<b>Application Ref:</b>	3/2025/0887			 Ribble Valley Borough Council <a href="http://www.ribblevalley.gov.uk">www.ribblevalley.gov.uk</a>
<b>Date Inspected:</b>	25/11/25	<b>Site Notice:</b>	N/A	
<b>Officer:</b>	LW			
<b>DELEGATED ITEM FILE REPORT:</b>				<b>REFUSAL</b>

<b>Development Description:</b>	Proposed construction of a detached garage in the front garden.
<b>Site Address/Location:</b>	53 Knowsley Road, Wilpshire, BB1 9PN.

drawing title	Proposed Plans
dwg purpose	
scale	1:100
@ sheet size A1	rev date 11/11/25
job number	V4-GA-001
drawing number	P-1
revision

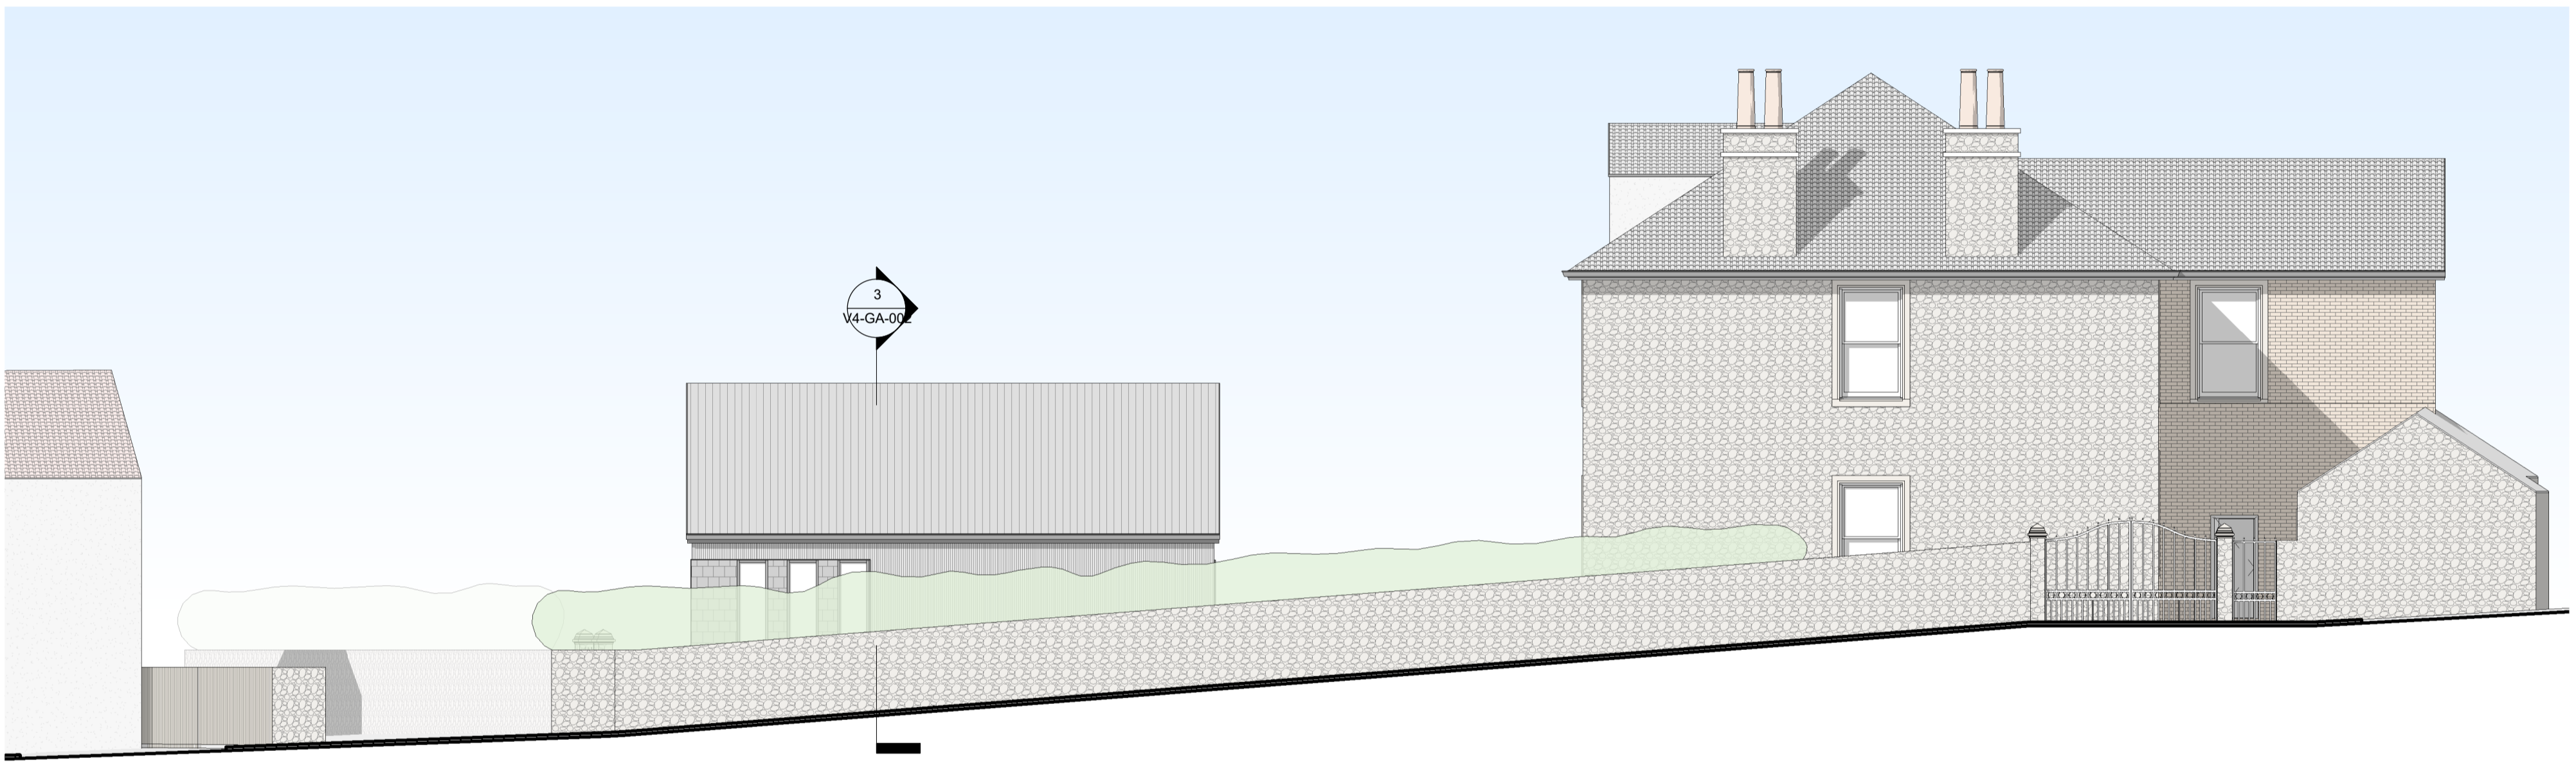
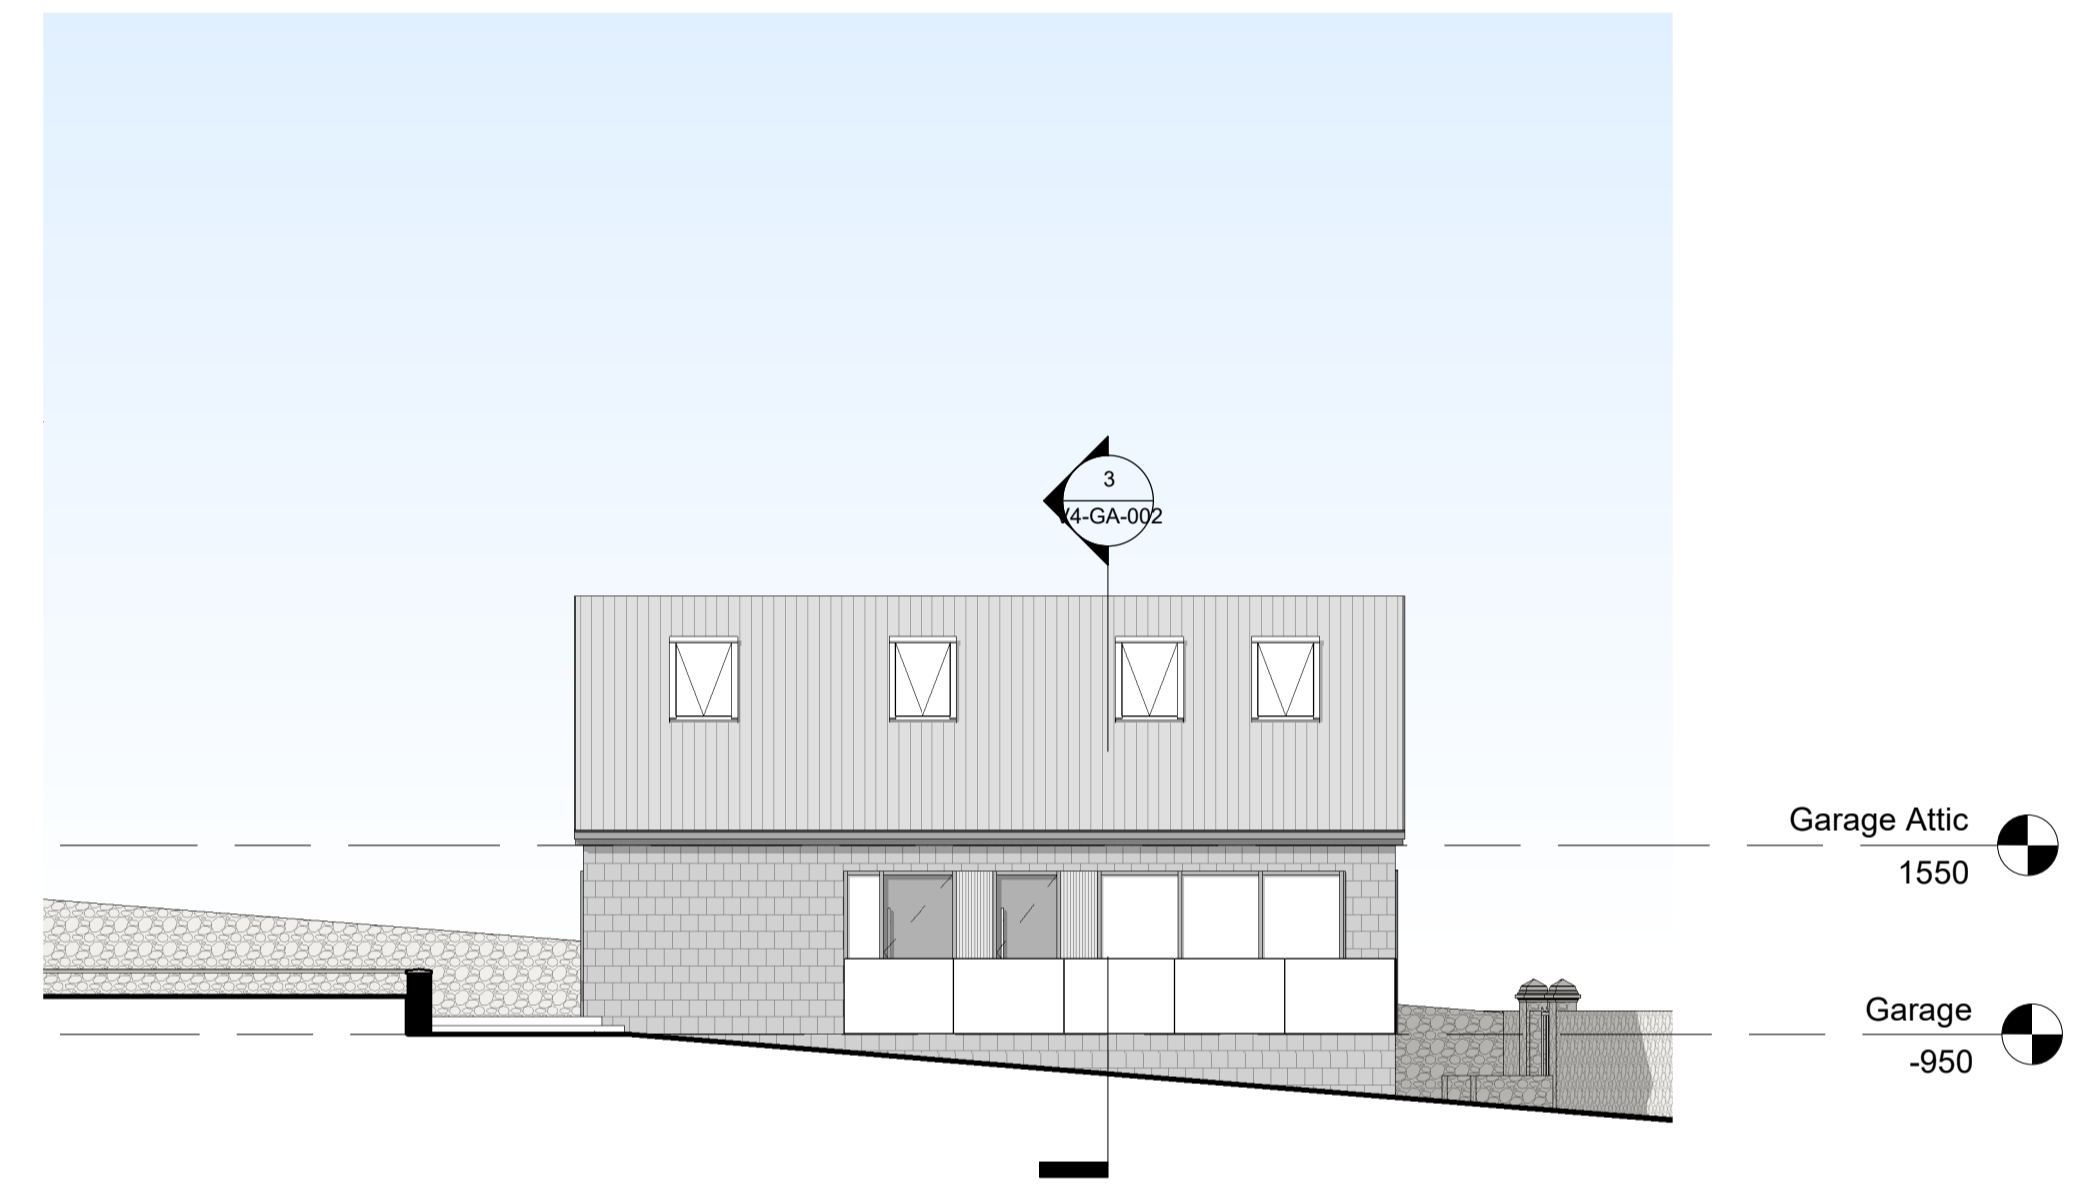
The outbuilding would measure 10.7m by 7.2m and would incorporate a pitched roof form measuring approximately 3.8m to the eaves and 6.8m to the ridge at its highest point. To the northern elevation a garage door and 1no. first floor window would be featured, while both a ground and first floor window would be included to the southern elevation. To the eastern elevation 3no. windows would be featured along with glazed patio doors and 2no. personnel doors to the western elevation which would open onto a raised patio area. Four rooflights would also be included to the western facing roof pitch.

The openings proposed to the northern and western facing elevations of the proposed building would provide views predominantly towards the private amenity space associated with the application property and therefore no new opportunities for direct overlooking or loss of privacy are anticipated in this respect. The windows proposed to the eastern elevation would also remain approximately 21m from the residential properties at No. 52a and 54 Knowsley Road, separated by the highway, and adequately screened by existing boundary treatment. The views afforded by the proposed ground floor openings to the southern gable elevation would also be screened by the existing boundary treatment; however, the

first-floor window would likely provide elevated views towards No.45 Knowsley Road resulting in a perceived sense of overlooking. Notwithstanding this, given this opening would only serve the first-floor attic space, a condition could be attached requiring this window to be obscure glazed in order to protect the amenity of No.45 Knowsley Road without significantly impacting the amenity of the development. As such, no significant concerns are raised in this respect.

Further to the above, whilst the development would incorporate elements of natural stone and a slate roof, it is not considered that the proposed use of composite cladding and large elements of glazing would

be sympathetic to, or reflective of, the primary dwellinghouse in as much that it would introduce a more contemporary style of development which in turn would be harmful to the dwellings inherent character and more traditional appearance. The extent of openings is also considered excessive in context with the buildings proposed use, particularly the 2no. first floor windows to the gable elevations and 4no. rooflights which would all serve the first-floor attic space. The overall design of the proposal would therefore appear discordant with respect to its intended use and within its surroundings, most notably within a garden setting where no other such large outbuildings are visible.
